PLANNING BOARD REPORT

The Forefront at Thompson's Point, Portland, Maine
Thompson's Point, Portland, Maine
Level III Site Plan and Subdivision Amendments
2013-249

Submitted to: Portland Planning Board Public Hearing Date: December 17, 2013 CBL: 201-A-5	Prepared by: Nell Donaldson, Planner Date: December 12, 2013 Planning Board Report Number: #59-13
---	---

PROJECT: BRICK NORTH BUILDING AT THE FOREFRONT AT THOMPSON'S POINT
 SHEET TITLE: STAND ALONE BRICK NORTH FIRE SAFETY COMPLIANCE PLAN
 CLIENT: FOREFRONT PARTNERS I, LP

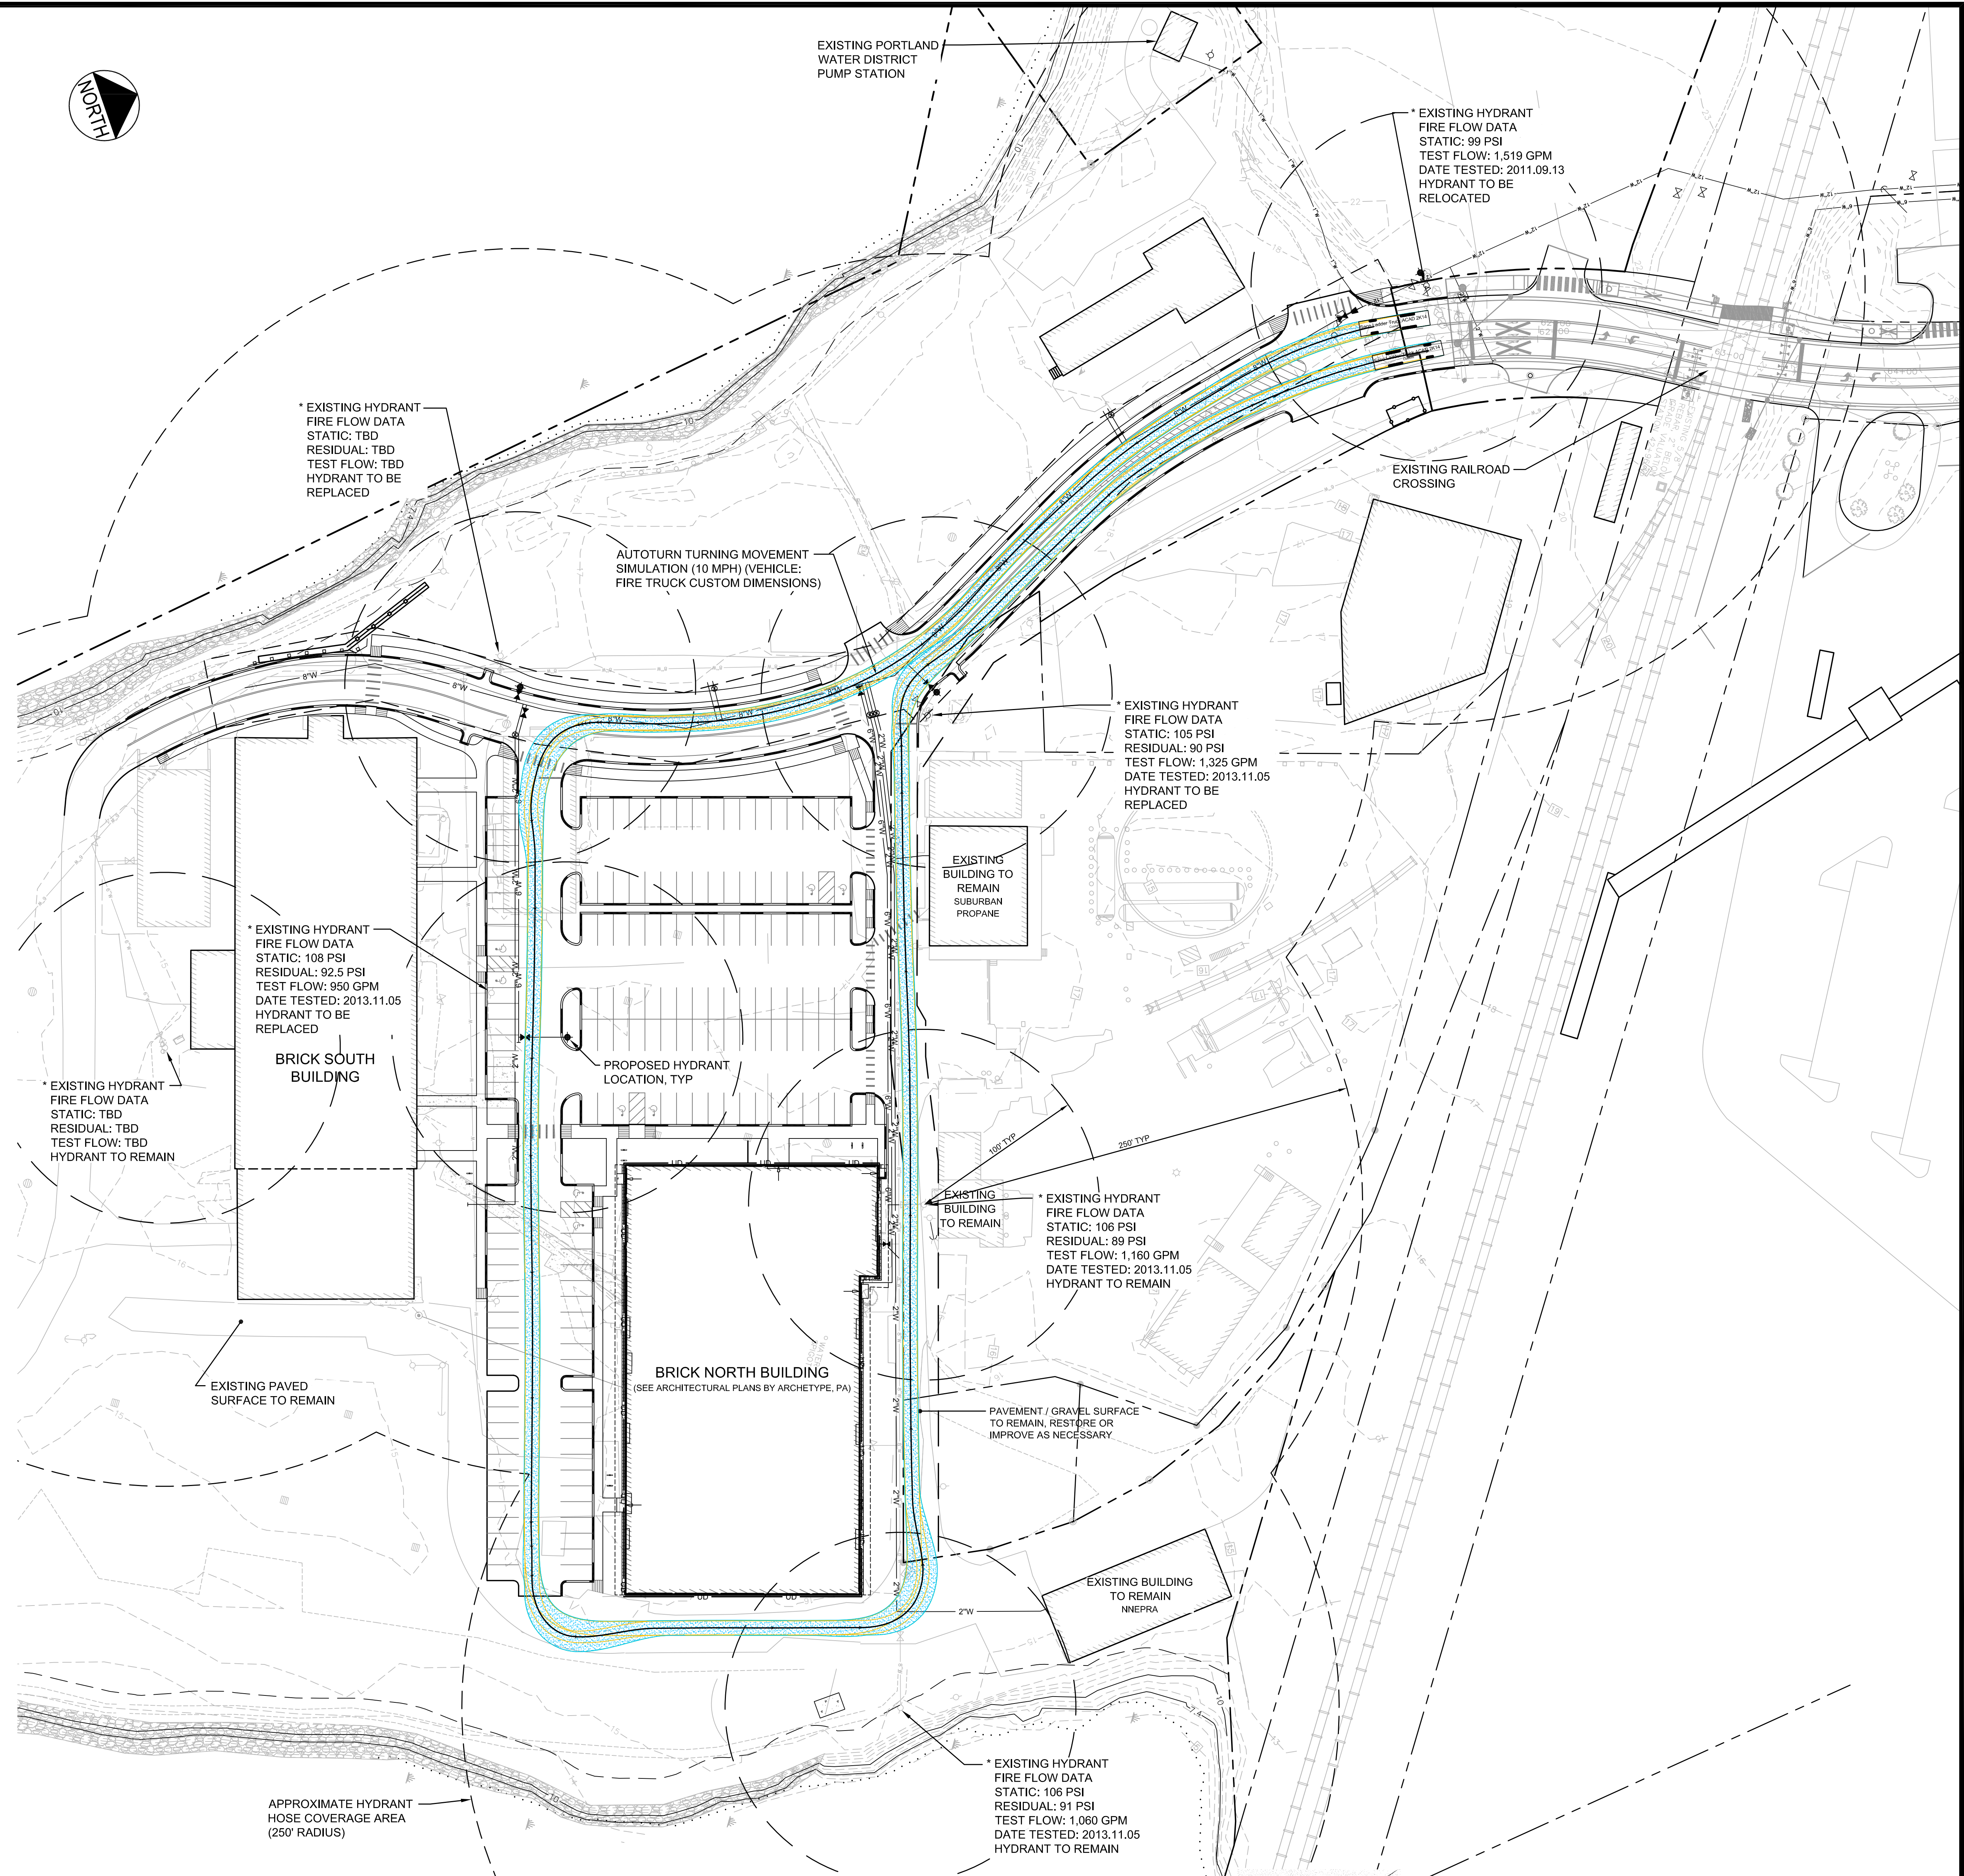
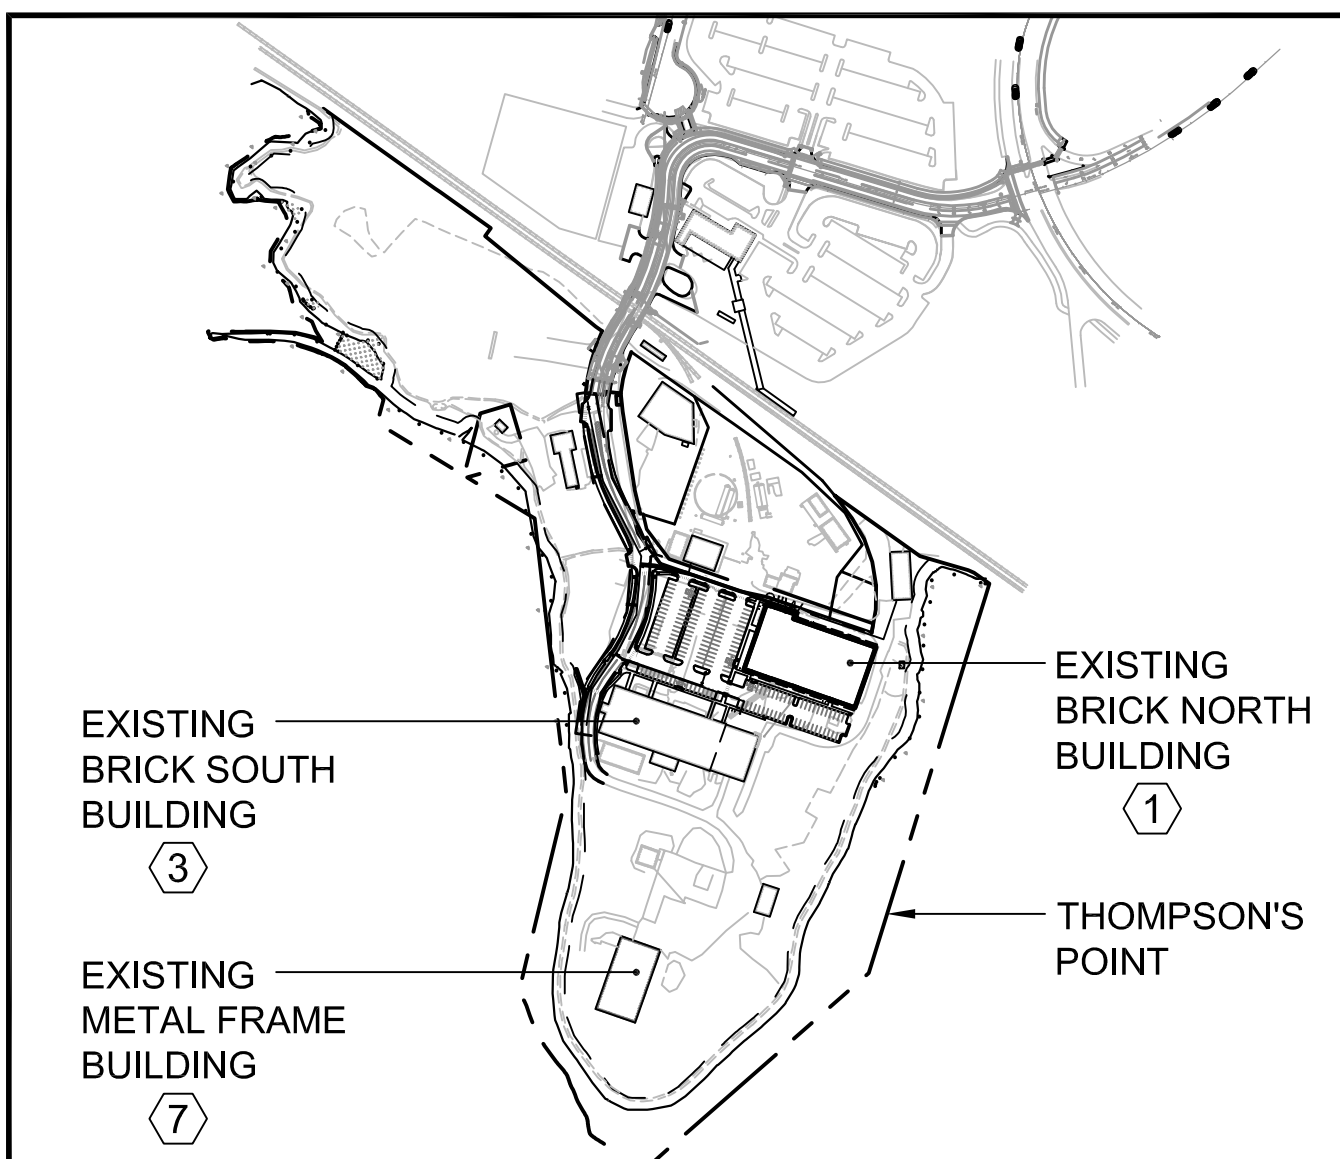
5. The applicant shall provide evidence of fire safety compliance as required by the city's Fire Prevention Bureau for review and approval by that department;

PROJECT: BRICK NORTH BUILDING AT THE FOREFRONT AT THOMPSON'S POINT
SHEET TITLE: STAND ALONE BRICK NORTH SITE LAYOUT PLAN
CLIENT: FOREFRONT PARTNERS | LP

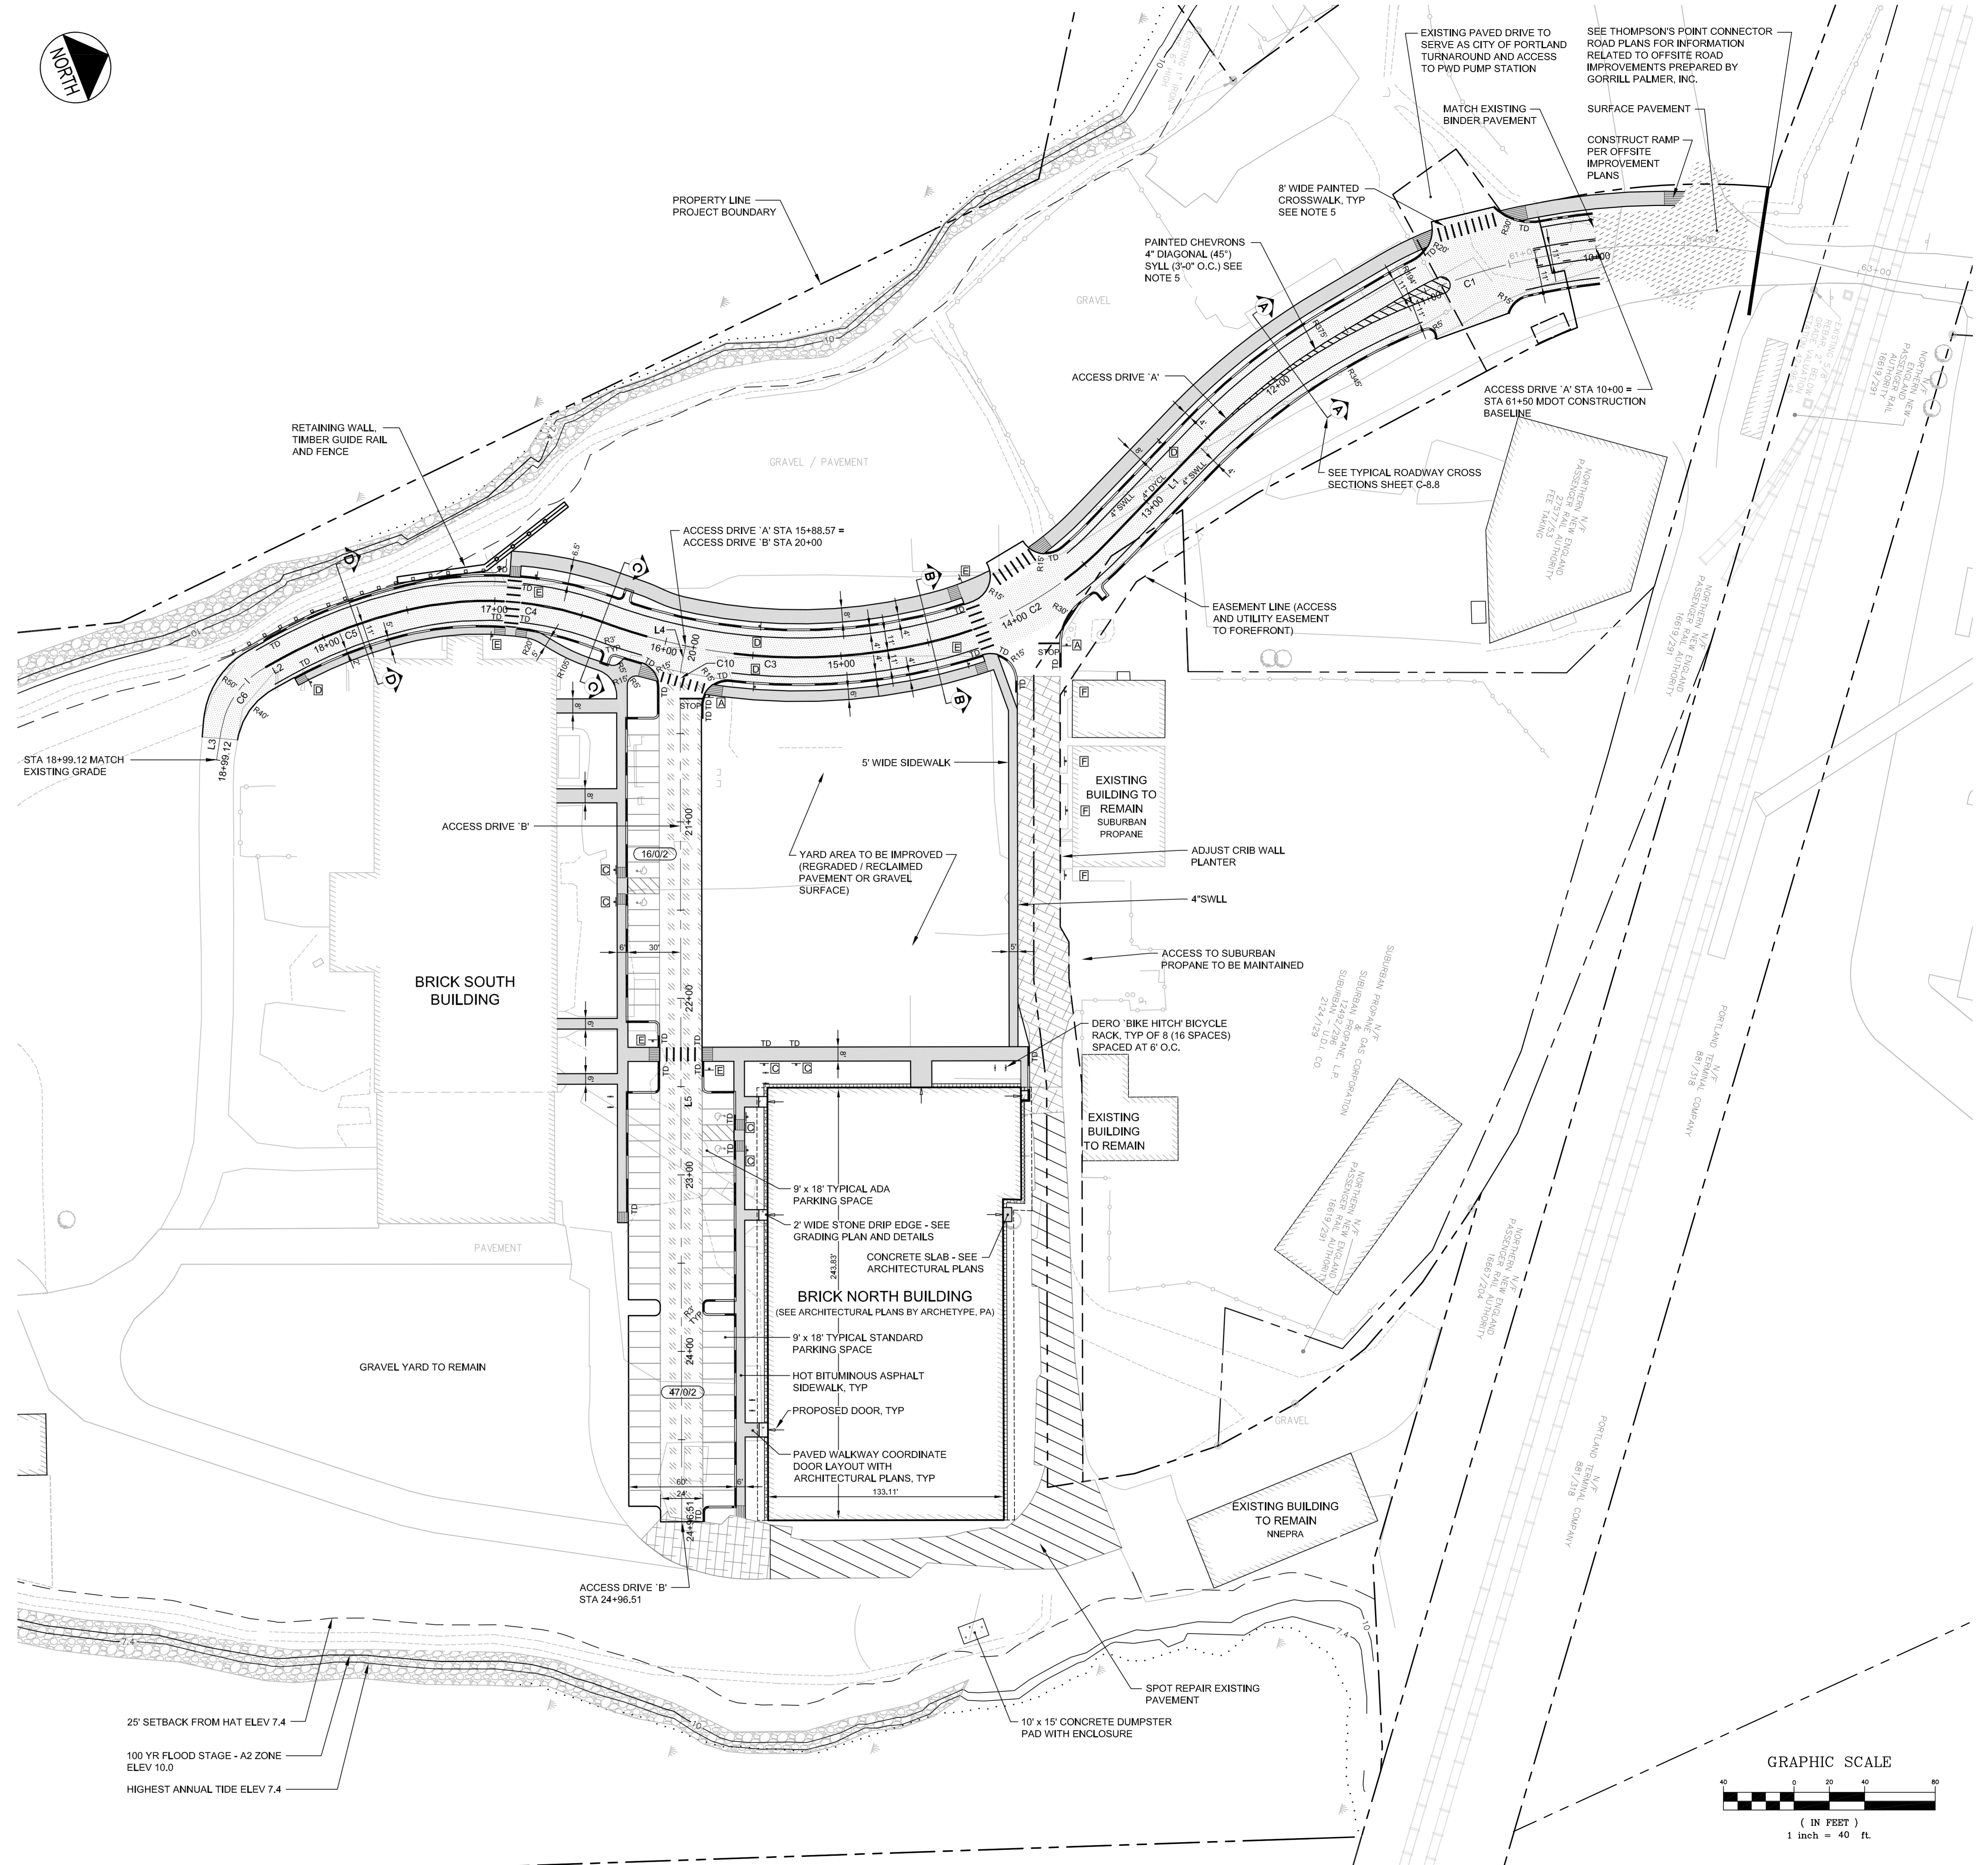
I have looked at the most recent submittals - revised 12/4/13 & uploaded to eplan on 12/9/13. The only thing that seems to have changed looking at the C-3.1 Site Layout Plan is the parking area. The plan is now showing 61 parking spaces provided which matches the 61 shown as required. Other than that I don't see anything else having changed from Marge's comments submitted on 11/27/13. She mentioned submitting floor plans showing the uses and their floor area to back up the submitted information. We have not received floor plans yet.

A crosswalk shall be added at the first intersection entering the site under the stand alone plan.
